Recommendation Report for Planning Permission for Works or Extension to a Dwelling

REF NO: A/11/20/HH

LOCATION: Thatched Corner
Ham Manor Way
Angmering
BN16 4JQ

PROPOSAL: Loft conversion and balcony and part conversion of garage to habitable use.

| REVISIONS                                                                                                                                               |                |
|---------------------------------------------------------------------------------------------------------------------------------------------------------|----------------|
| DRAWING<br>PROPOSED<br>DATE: DECEMBER 2019<br>DRAWN: T. Murray                                                                                          | SCALE<br>1/100 |

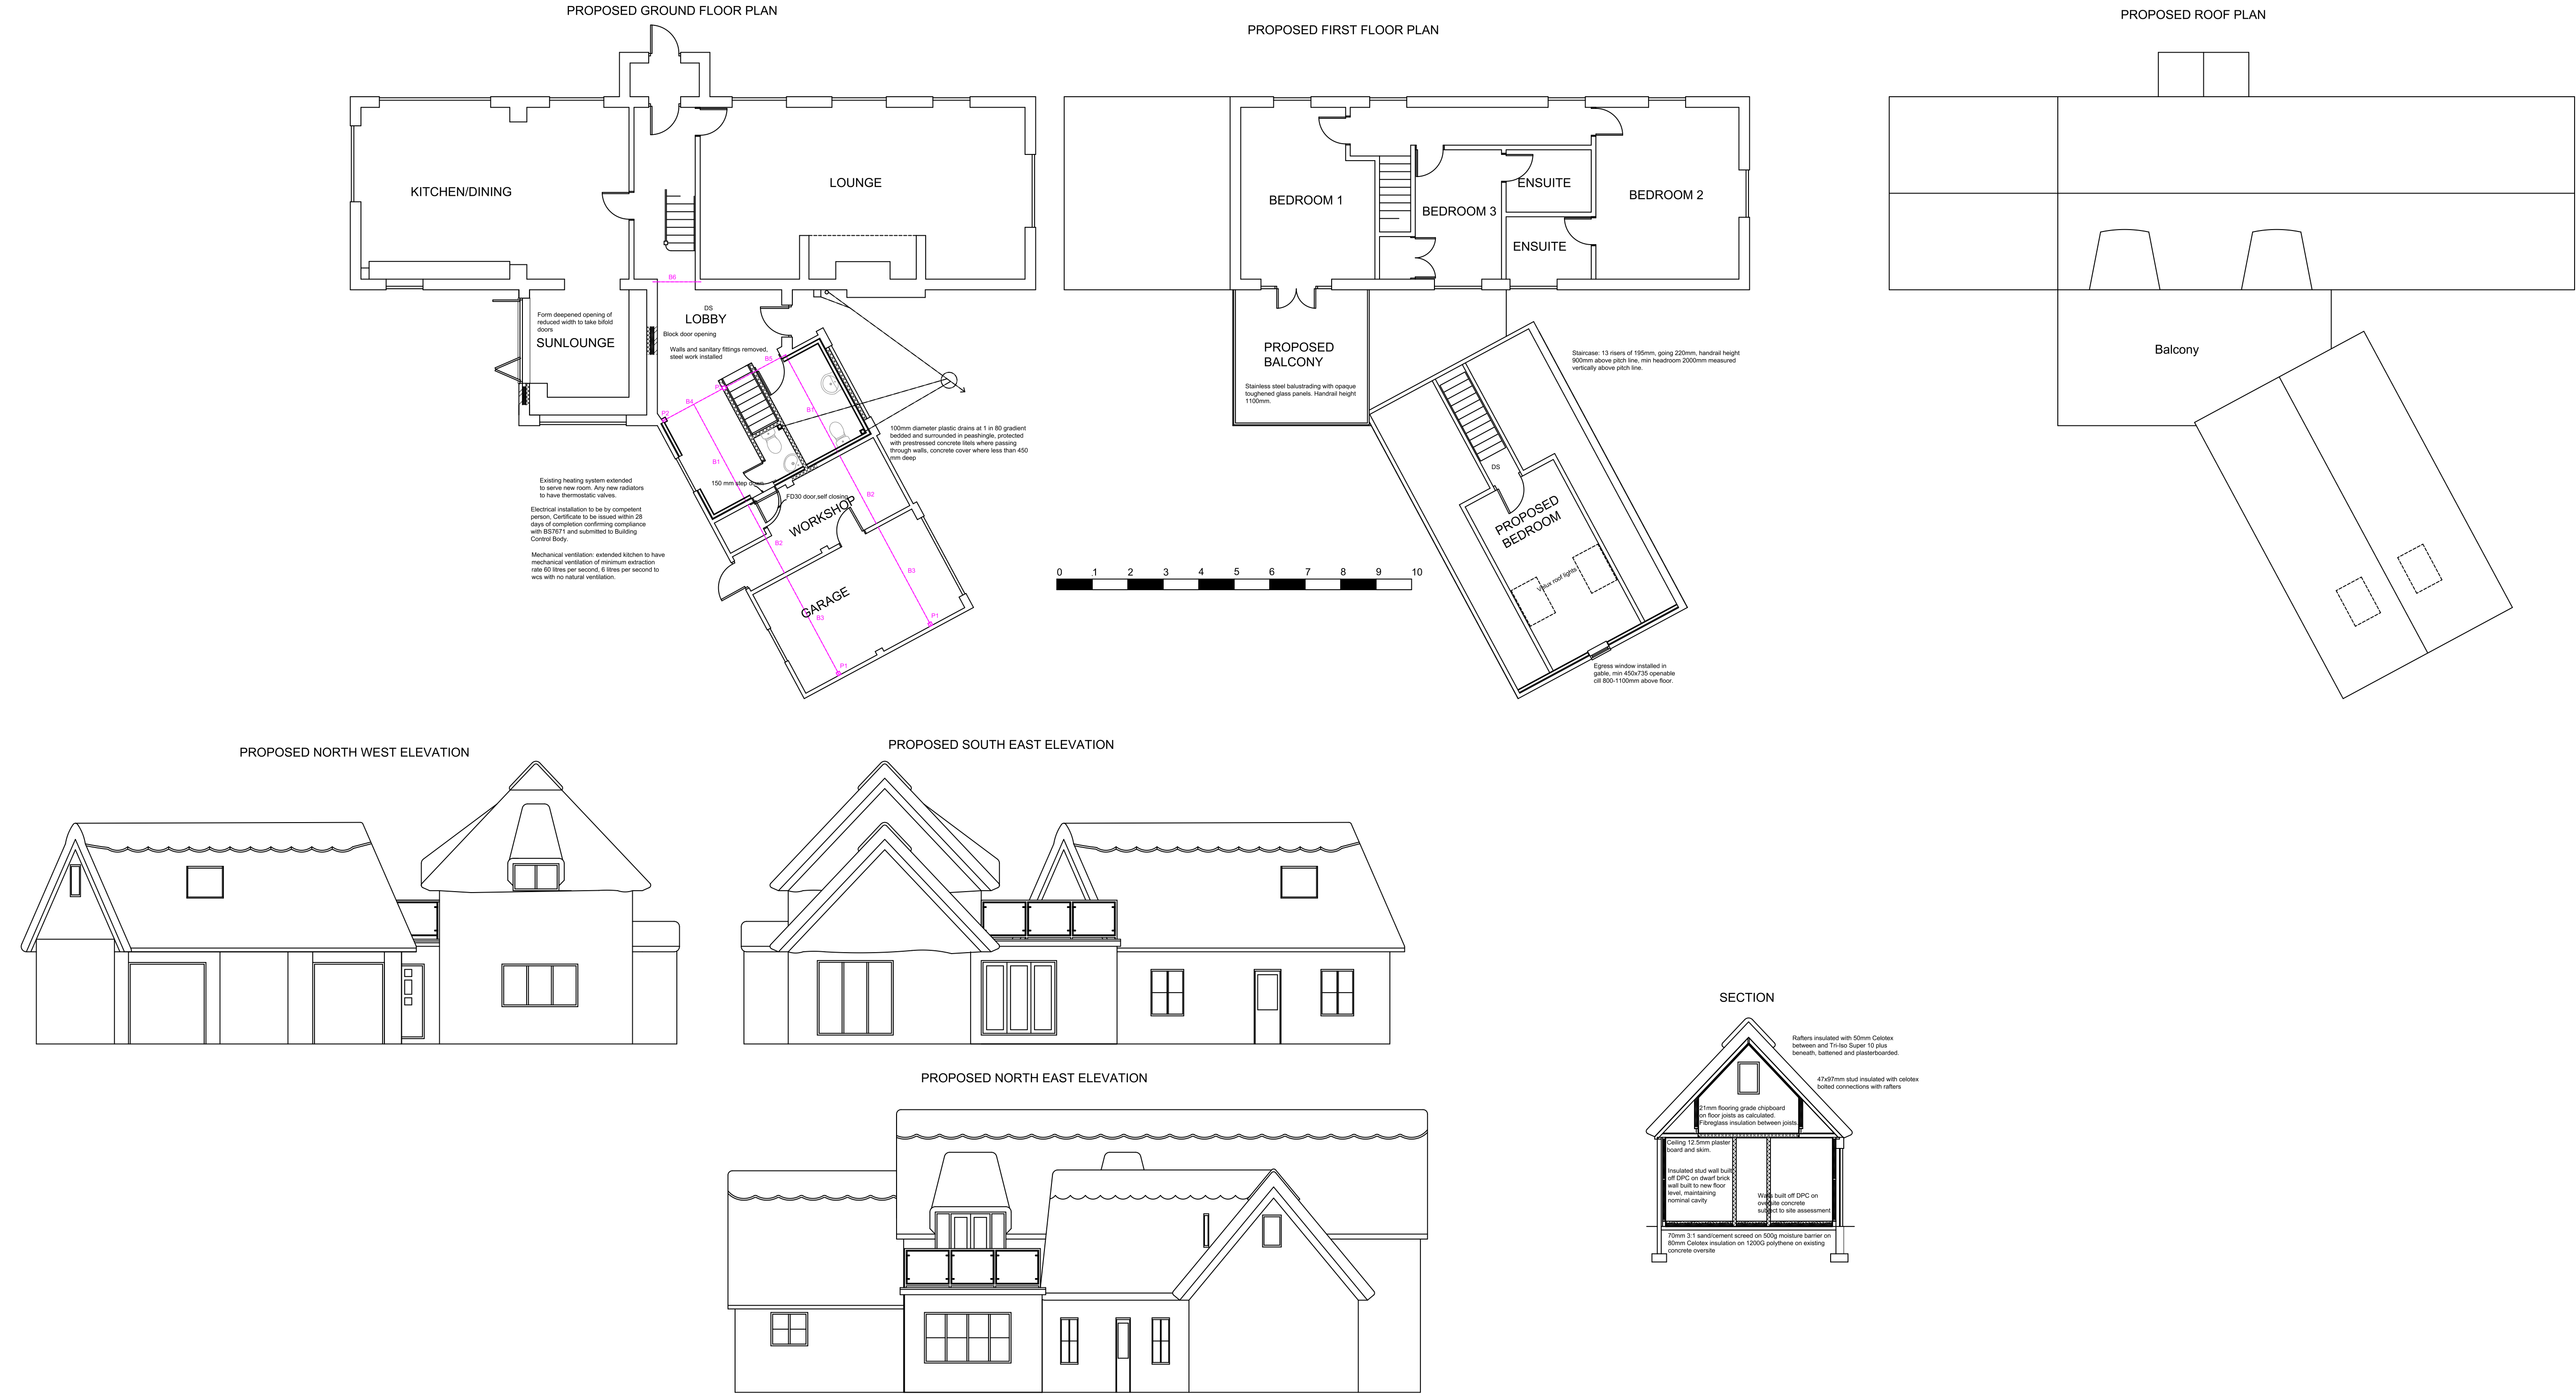
The proposed alterations to the garage are predominantly internal, and therefore, have a limited impact upon the character of the host dwelling, or its wider locality. The addition of Velux windows into the roof slopes of the garage is not considered to result in a harmful impact upon the visual appearance of the host dwelling on the whole.

The proposed balcony will be bordered by opaque glass, with stainless steel balustrading. This provides a stark contrast to the materials used in the construction of the host dwelling, however, the proposed materials are deemed to remain sympathetic to the character of the host dwelling.

The proposed development is not considered to result in any significantly harmful impact overshadowing or overbearing impact upon the occupiers of neighbouring dwellings. This is due to the lack of built form proposed under the application. With regard to loss of privacy, the proposed balcony is considered to result in overlooking of the property to the North, and as such, it will be conditioned to ensure that obscure glazing is installed along the North-Eastern boundary of the balcony in order to prevent these views. The balcony is not considered to result in any loss of privacy to its South-Eastern elevation, as a

result of separation distance and boundary treatment.

Reason: To comply with Section 91 of the Town and Country Planning Act 1990 (as amended).
- 2 The development hereby approved shall be carried out in accordance with the following approved plans:
 - Loft Conversion and Balcony - Block Plan - 19/89/5 - December 2019
 - Loft Conversion and Balcony - Proposed - 18/89/4 - December 2019
Reason: For the avoidance of doubt and in the interests of amenity and the environment in accordance with policy D DM1 of the Arun Local Plan.
- 3 Before the balcony hereby permitted comes into use, details of 1.8m high obscure screening for the North-Eastern elevation of the balcony shall be submitted to and approved by the Local Planning Authority and the balcony shall not come into use until such screening has been

erected in accordance with the approved plans and shall thereafter remain in perpetuity.
